Please ask for: Nicola Moore
Email: nicola.moore@arun.gov.uk
Telephone: Ext 37944
Our Ref: Y/150/21/HH
Your Ref:
Date: 28th October 2021

Application for Planning Permission for Works or Extension to a Dwelling

Development: Detached single storey home office/garden building in rear garden.
Location: 15 Kings Close Yapton BN18 0EX

Site Plan shows area bounded by: 497875.6, 102996.65 498017.02, 103138.07 (at a scale of 1:1250), OSGridRef: SU9794 306. The representation of a road, track or path is no evidence of a right of way. The representation of features as lines is no evidence of a property boundary.

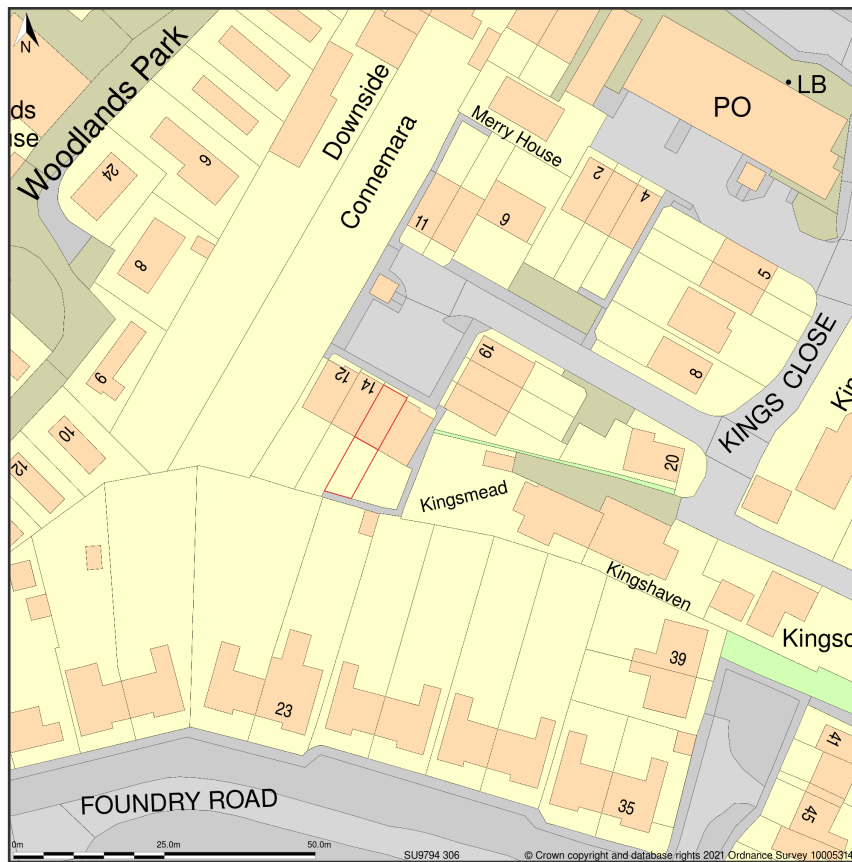
Only the application site should be edged in red. Any other land owned by the applicant but not included in the application, should be edged in blue. Please accordingly and re submit at a scale of 1:1250 or 1:2500 for rural areas. Further details of what must be included on the plan can be found in the Validation Requirements List.

Block Plan shows area bounded by: 497891.95, 103025.92 497981.95, 103115.92 (at a scale of 1:500), OSGridRef: SU9793 307. The representation of a road, track or path is no evidence of a right of way. The representation of features as lines is no evidence of a property boundary.

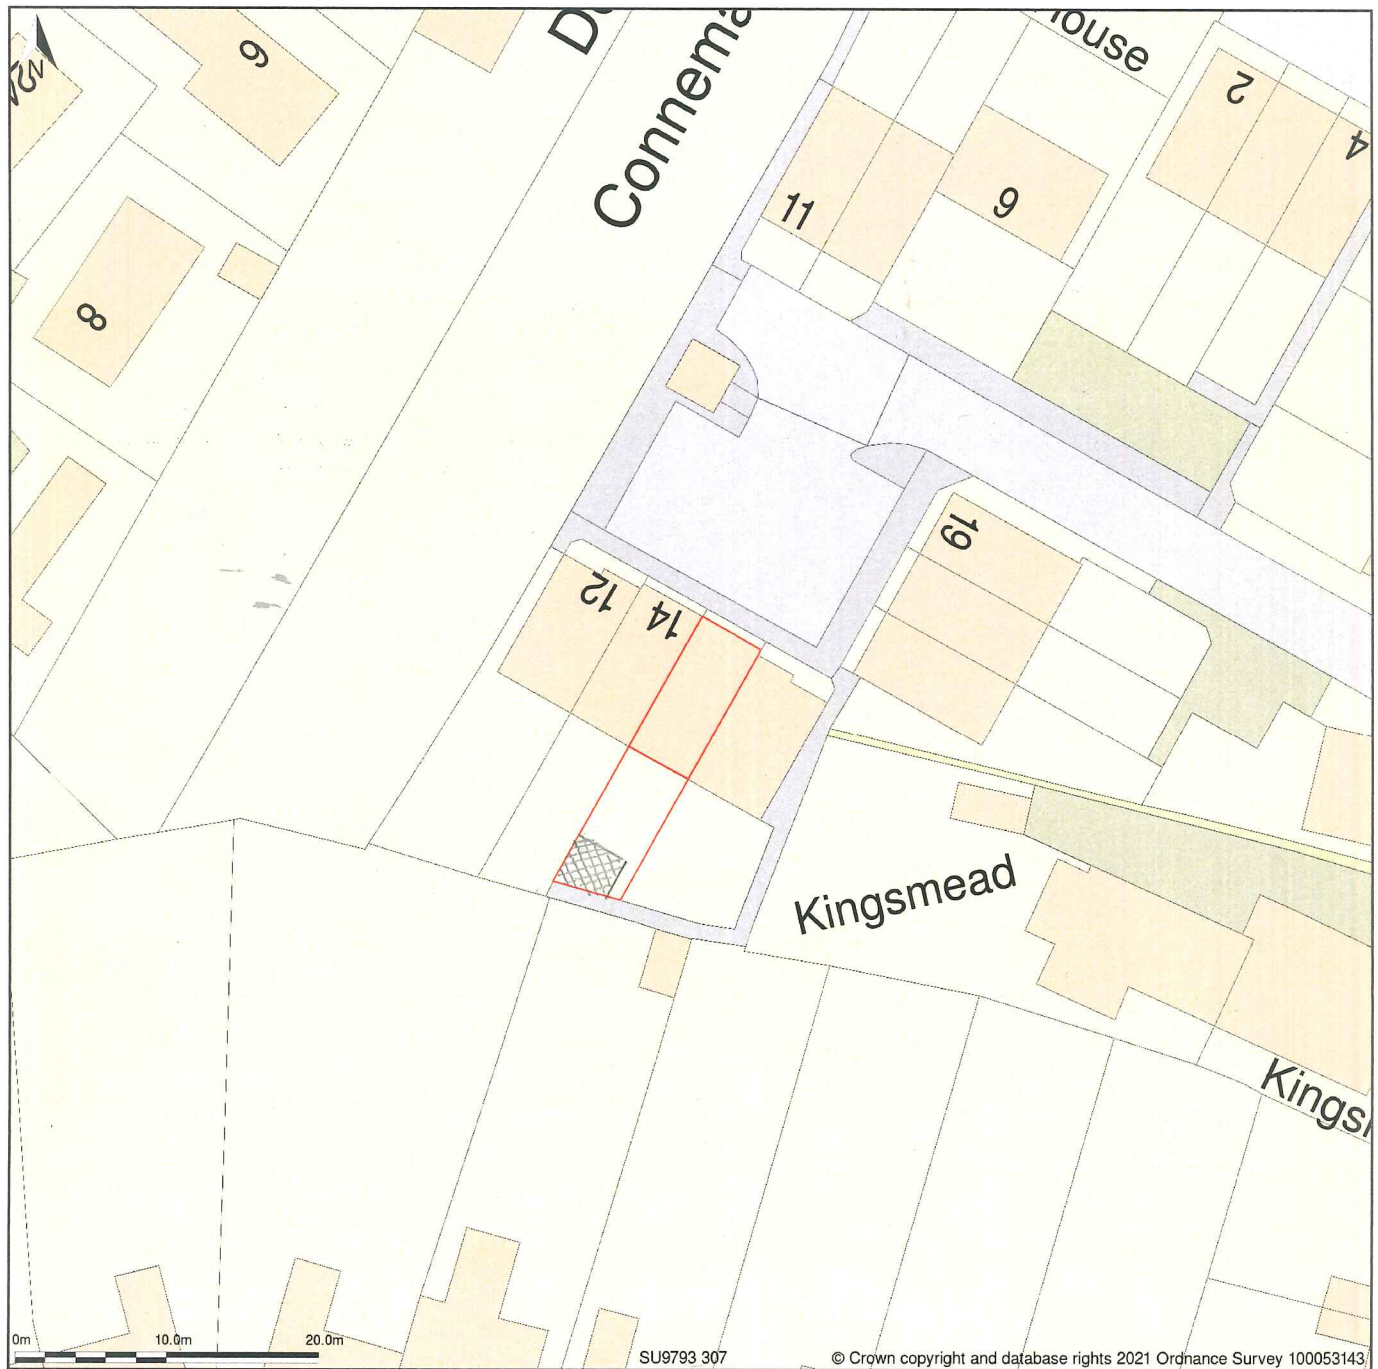
The submitted Block Plan does not scale correctly at 1:500 and should include distances to boundaries from the proposed development. Please amend accordingly and re submit. Further details of what must be included on the plan can be found in the Validation Requirements List.
